**Consultation Response from Emma Mills
 KC Landscape**

Application No:	2021/94280
Proposed Development:	Erection of 67 dwellings with associated works
Location:	land at, Lady Ann Road, Soothill, Batley, WF17 0PY
Applicant/Agent:	Self Architects
Planning Officer	Nick Hirst
Date Responded:	16.12.21 rev 22.12.21, and rev again 03.01.23
Responding Officer:	EM
Responding Ref:	KK139 rev 2

1. Precedent planting
2. Native hedgerow
3. Wild flower meadow
4. Path with planting
5. & 6. Community orchard
7. Wild grasses
8. & 9. Street trees and front gardens

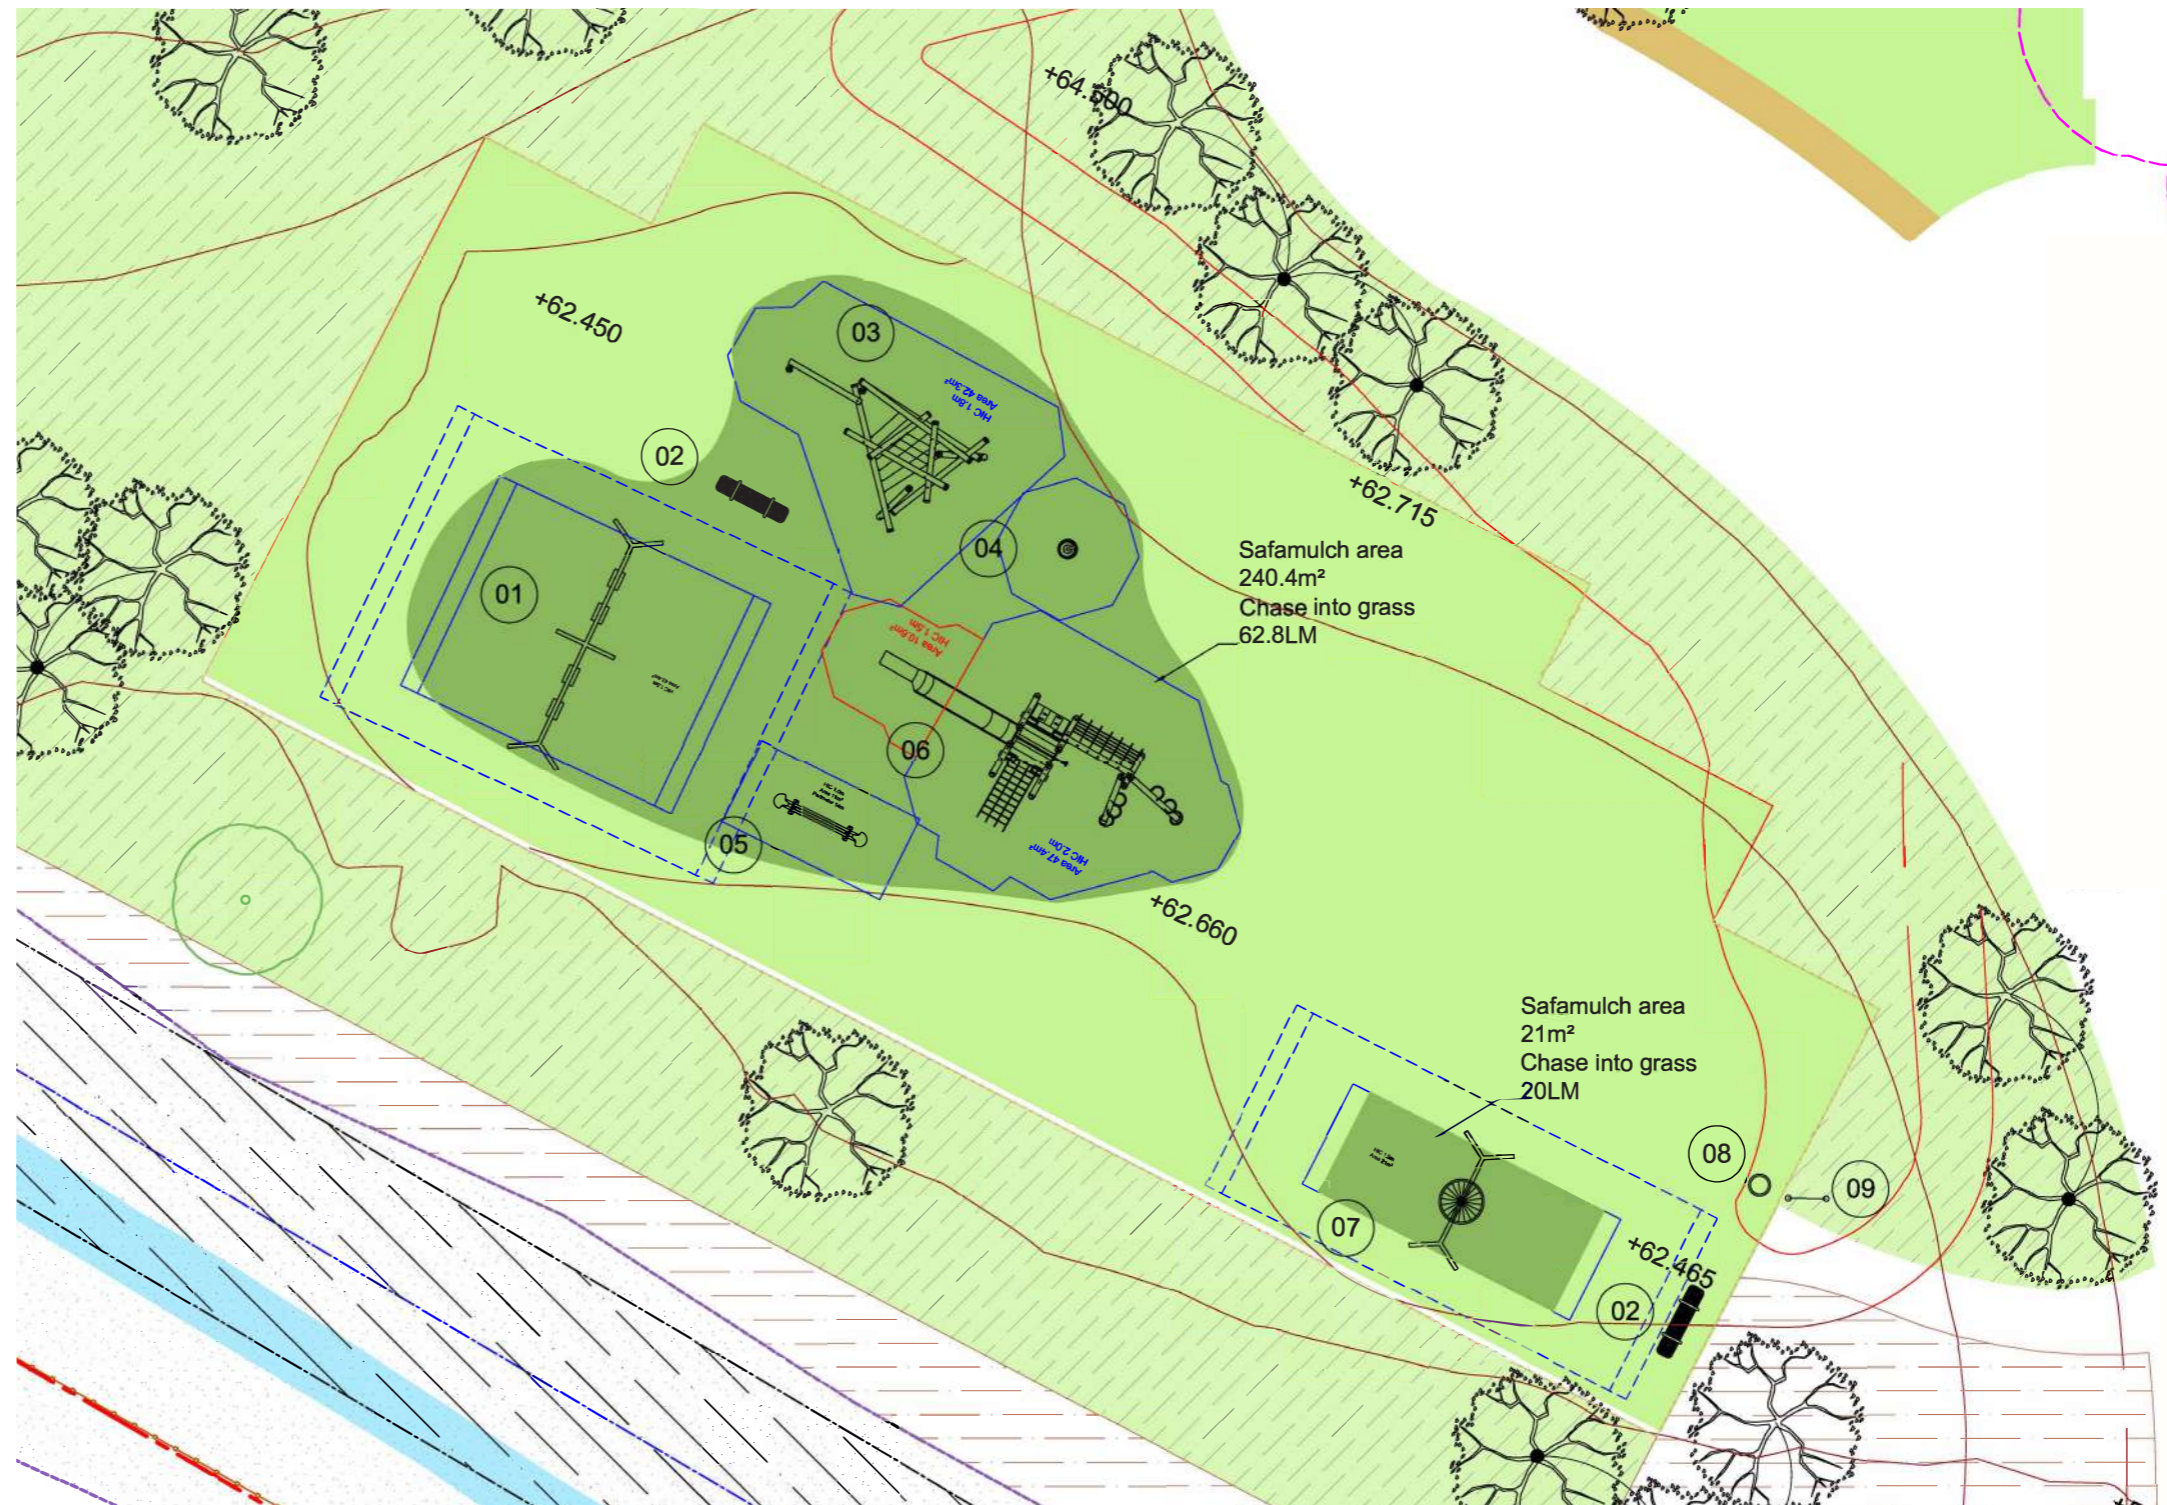
Landscape Context and Concept, Landscape Design In this layout, the trees are in front gardens rather than street trees, possibly due to the constrained space, and whilst tree planting to the frontages are welcome.

Proposed tree species and size etc details will be required, also we presume there be root barriers given their proximity to the rear of the proposed pavements and driveways – full details will need to be provided prior to landscape scheme approval. We would not want the proposed trees removed to necessitate s38 road adoption further down the line.

Hedgerows are welcomed to break up the dominance of hard surfaces/car parking to frontages, species, sizes and planting density details will be required.

The landscaping proposals submitted along with the planning application, are welcomed however, further clarification on proposed species & mixes for elements such as native shrub mix, native & formal hedgerows and trees are requested. In addition, details of the “wildflower meadow on regraded embankments” should also be detailed within the proposed soft landscape plans/specification.

Tree planting locations should be well thought out and trees positioned for their future growth and long term presence – also so as not to potentially damage the adjacent hard surfaces, **root barriers** also need to be shown where adjacent to the pavement.

## Equipment List

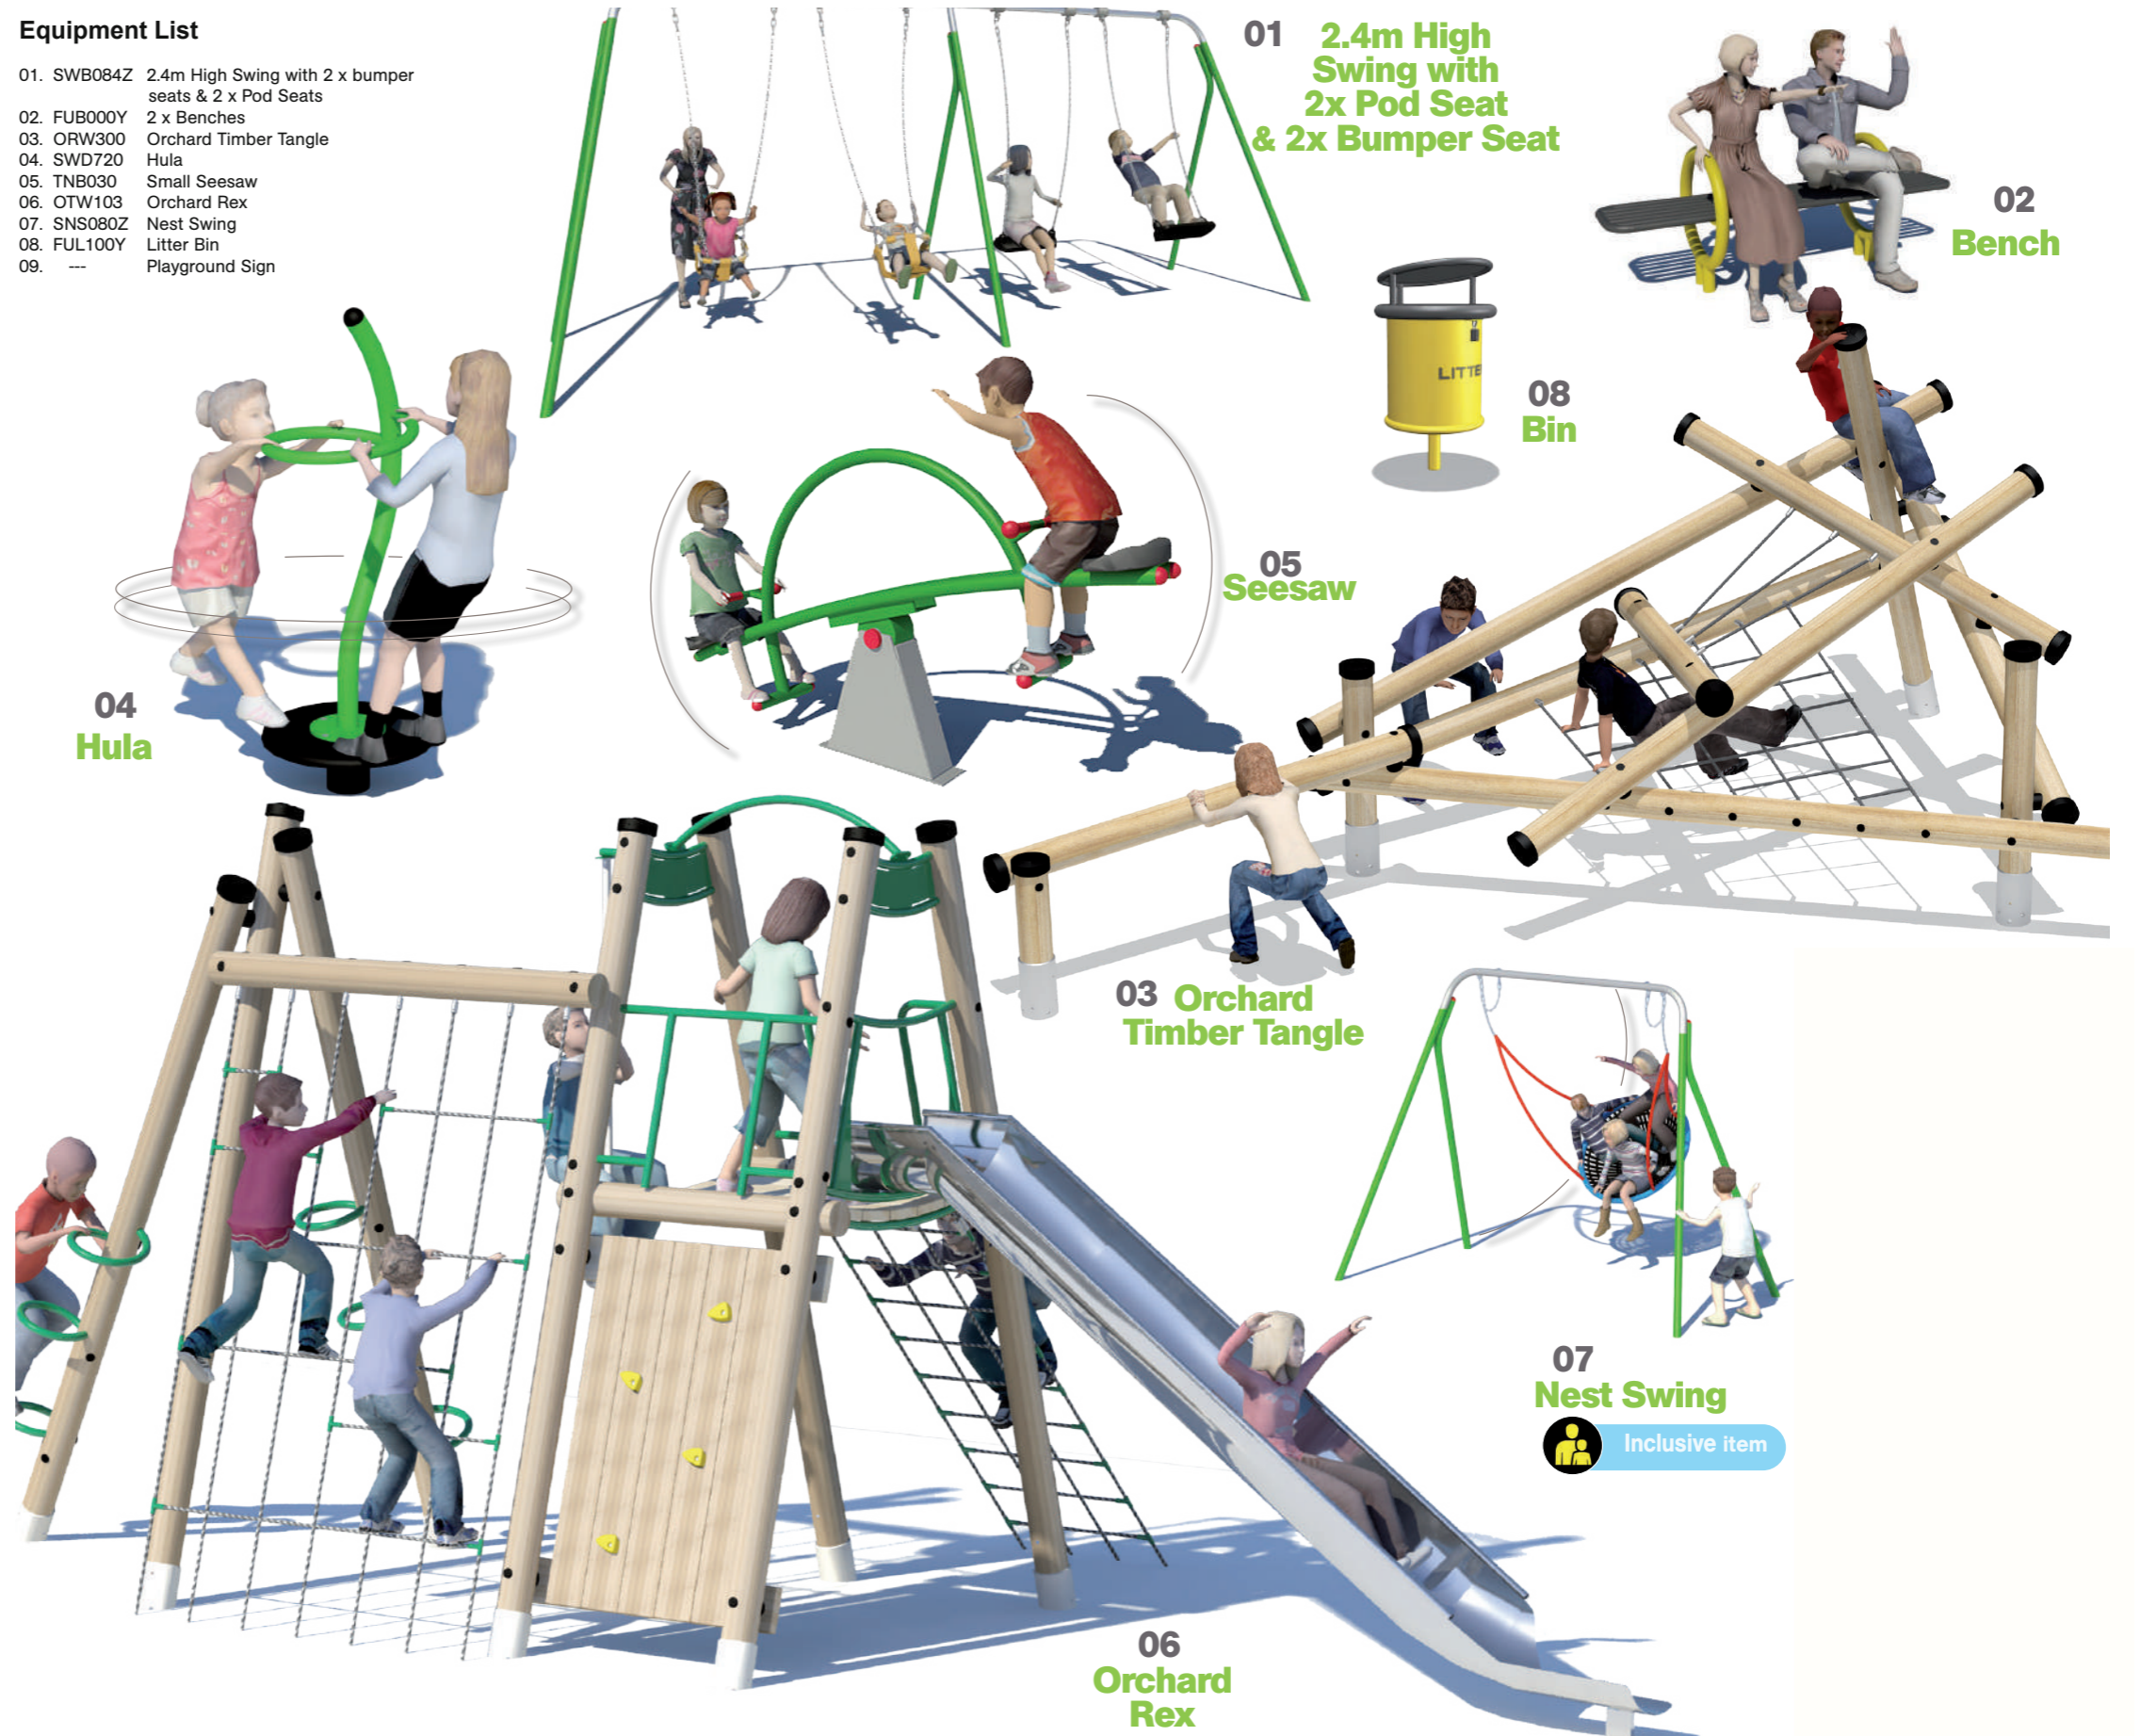
1. is it possible to install this play area OVER the attenuation tank as some of the footings for the play items require large concrete foundations?
2. Will there be inspection covers protruding through the safety surfacing?
3. Will it be fully meet BS EN 1176 & 1177 over an attenuation tank?
4. consider the equalities Act and accessibility- Safamulch is bound and therefore better for access for all, however, getting from the entrance path to the equipment and between the nest swing and the rest of the equipment is over grass which could get muddy and slippery, especially along well worn routes and access points – at the entrances.
5. The play equipment plan – list and location does not show the two entrance points which the Landscape Masterplan and Landscape proposals plan 1 shows. Plans need to be consistent for the s.106 agreement.

Good range of pieces of equipment included, compliments the offer in the vicinity, however, we would recommend this is metal play equipment in this location for durability (one of the pieces looks like a timber log stack climber with nets – is there a metal version?). Equipment appears congested in one area to the south – is there a reason for this?

No surfaced link path to the community growing area indicated – needs to be accessible as far as practicable for widest use by people of all abilities.

Natural playful elements such as boulders are welcomed, perhaps need connecting into the playable space and features a little? Used for linking other natural features or equipped play elements?
